Please ask for: Nicola Moore
Email: nicola.moore@arun.gov.uk
Telephone: Ext 37944
Our Ref: AW/272/21/HH
Your Ref:
Date: 11th August 2021

Application for Planning Permission for Works or Extension to a Dwelling

Development: Conversion of garage to kitchen
Location: 73 Marlborough Court Bognor Regis PO21 5QJ

Drawing No.
3 (22) 00

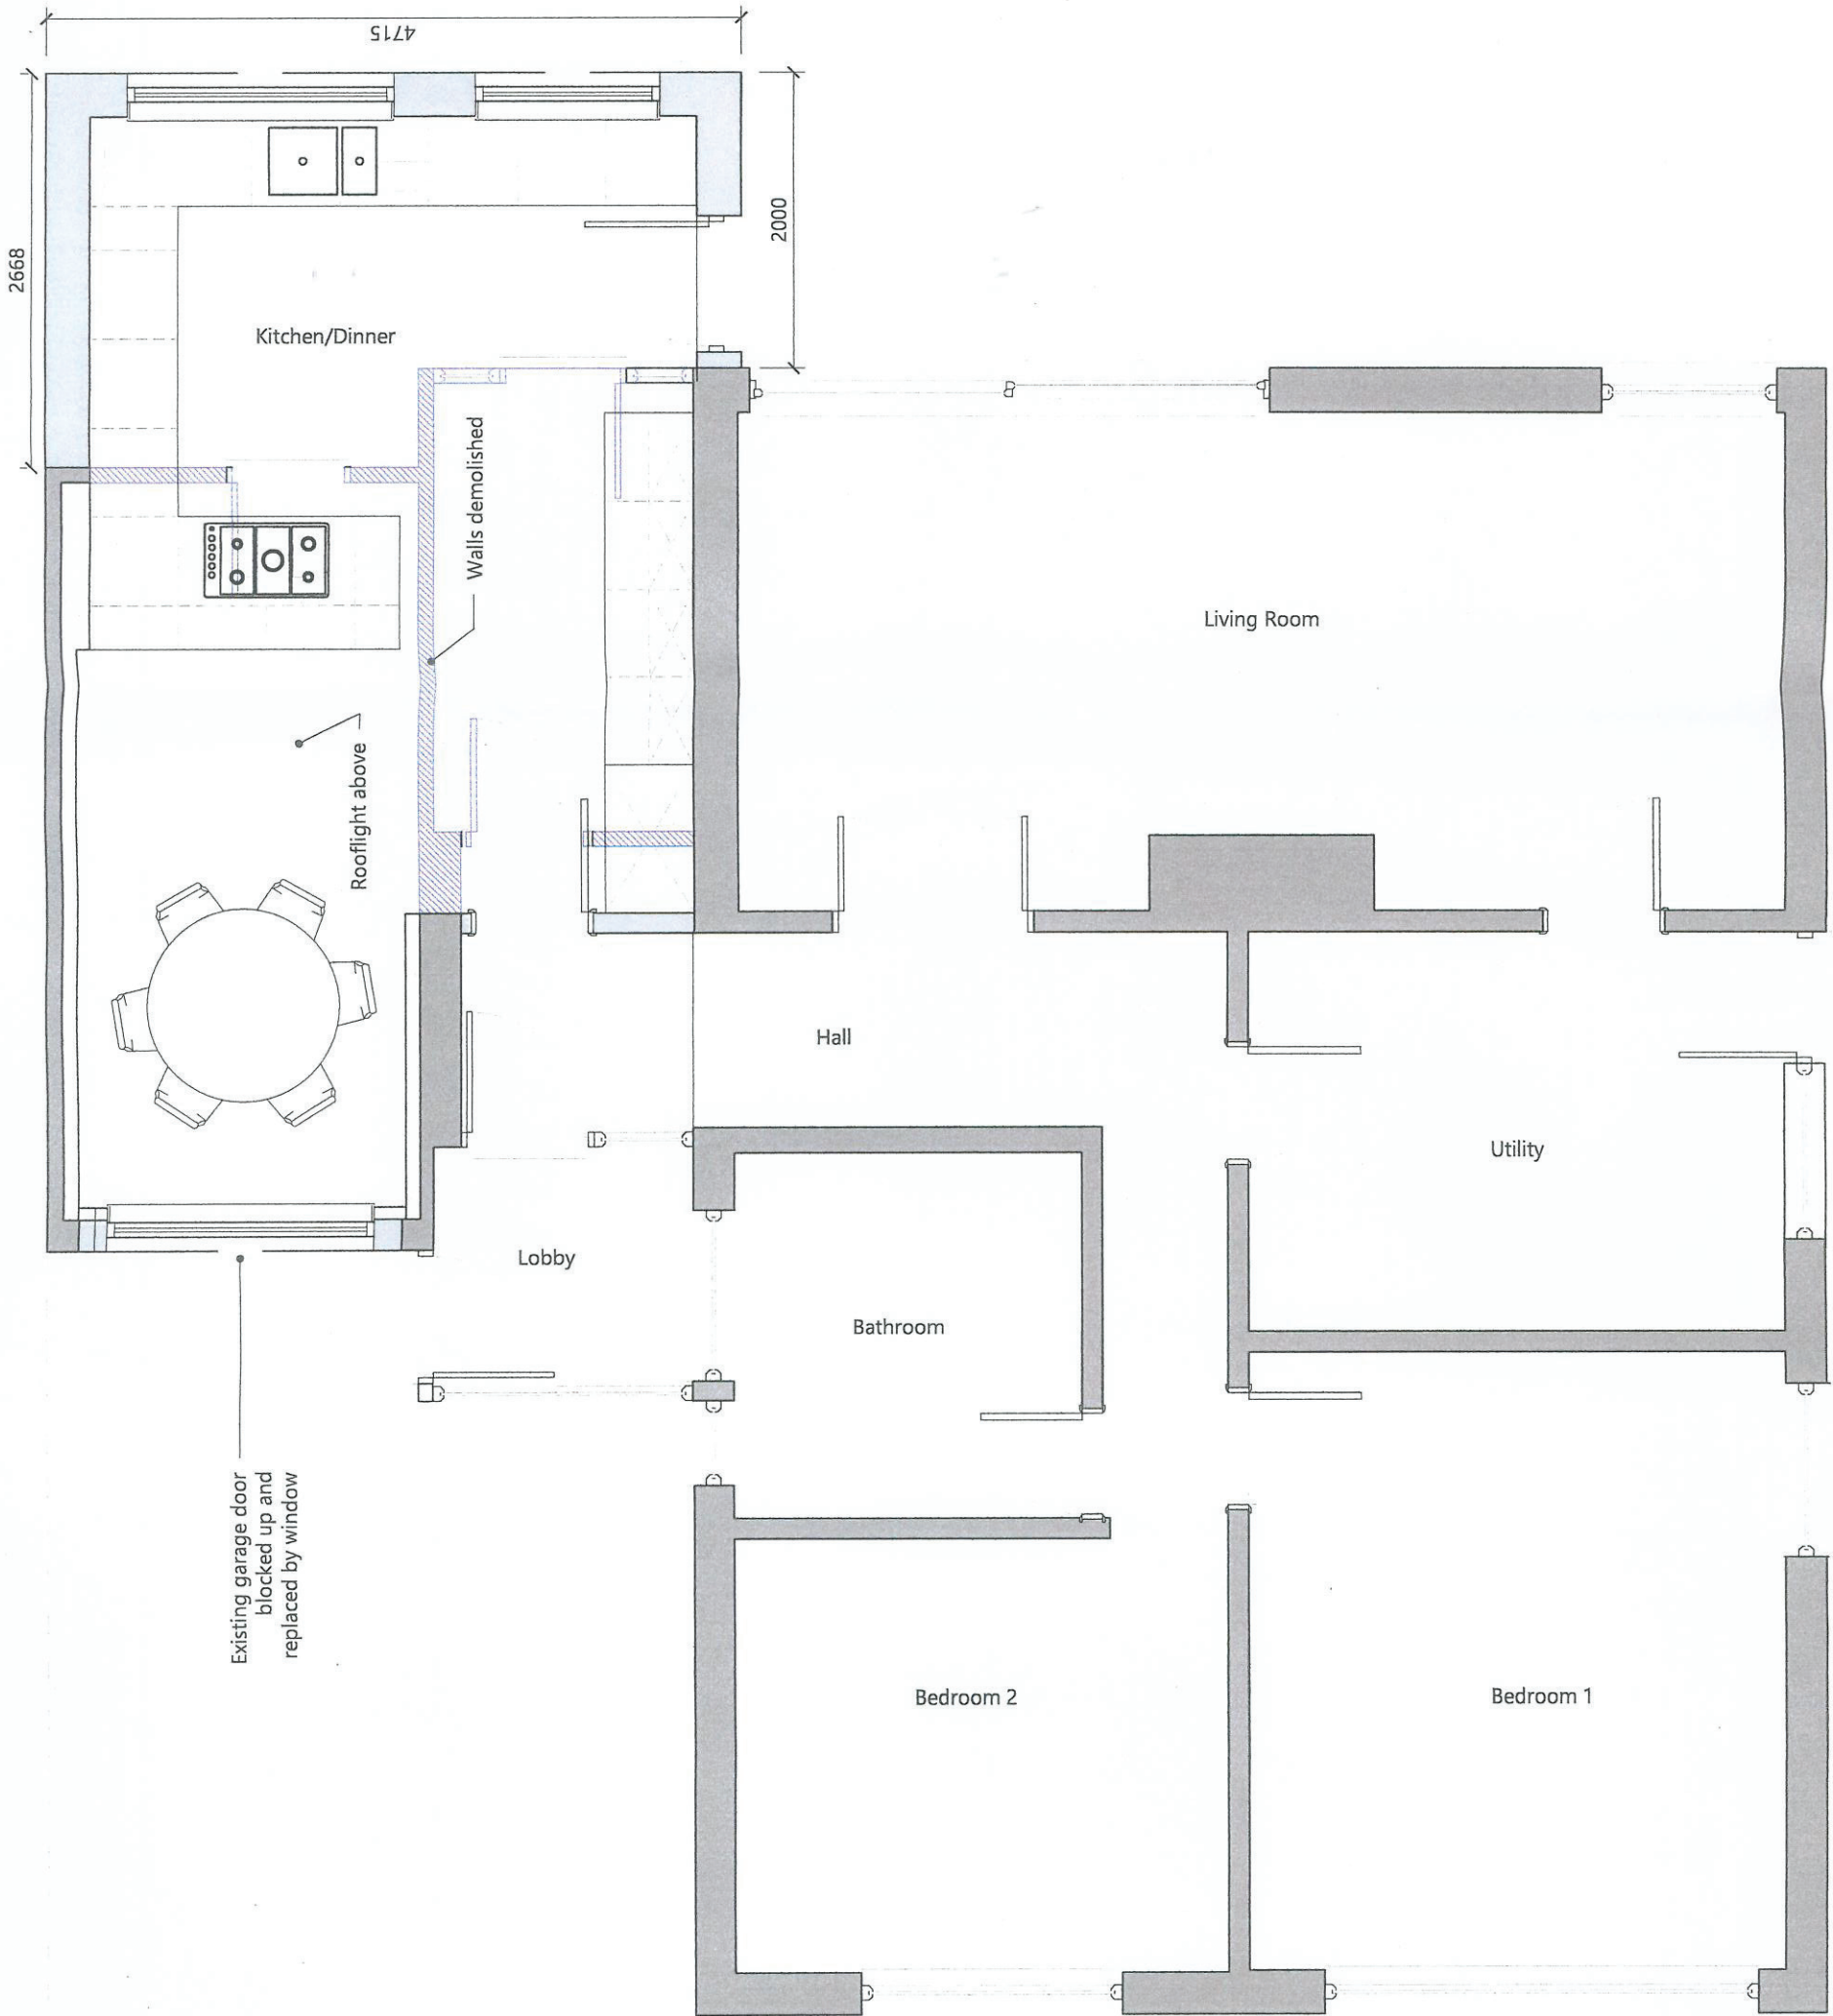
Please clearly label the Proposed Floor Plans (Dwg No 3 (22) 00) and re submit.

Site Location & Block Plan

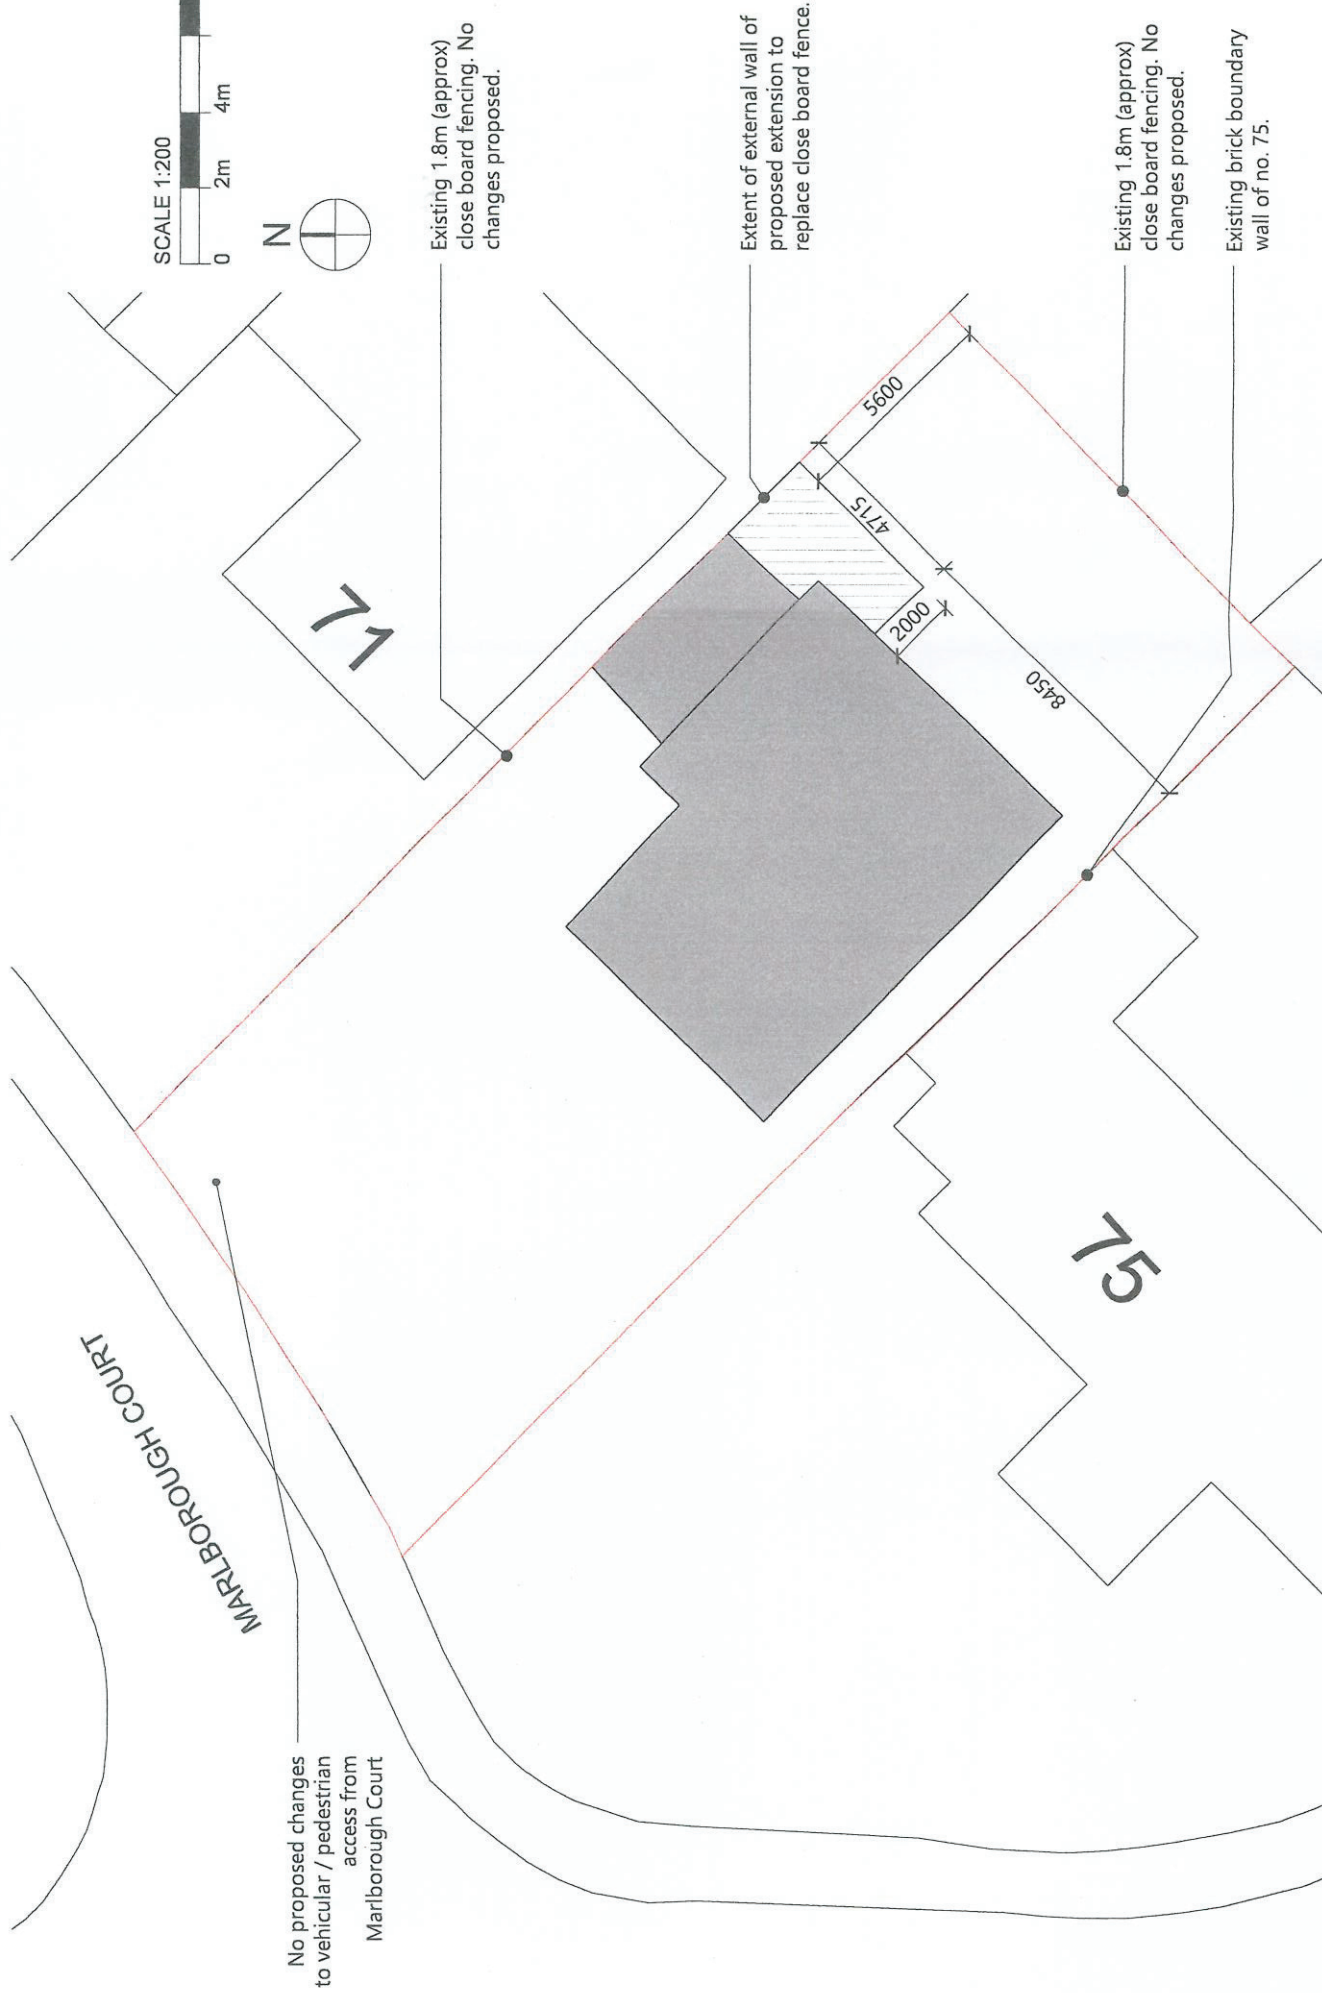
Location Plan

The application site should be clearly edged in red. Please amend accordingly and re submit. Further details of what must be included on the plan can be found in the Validation Requirements List.
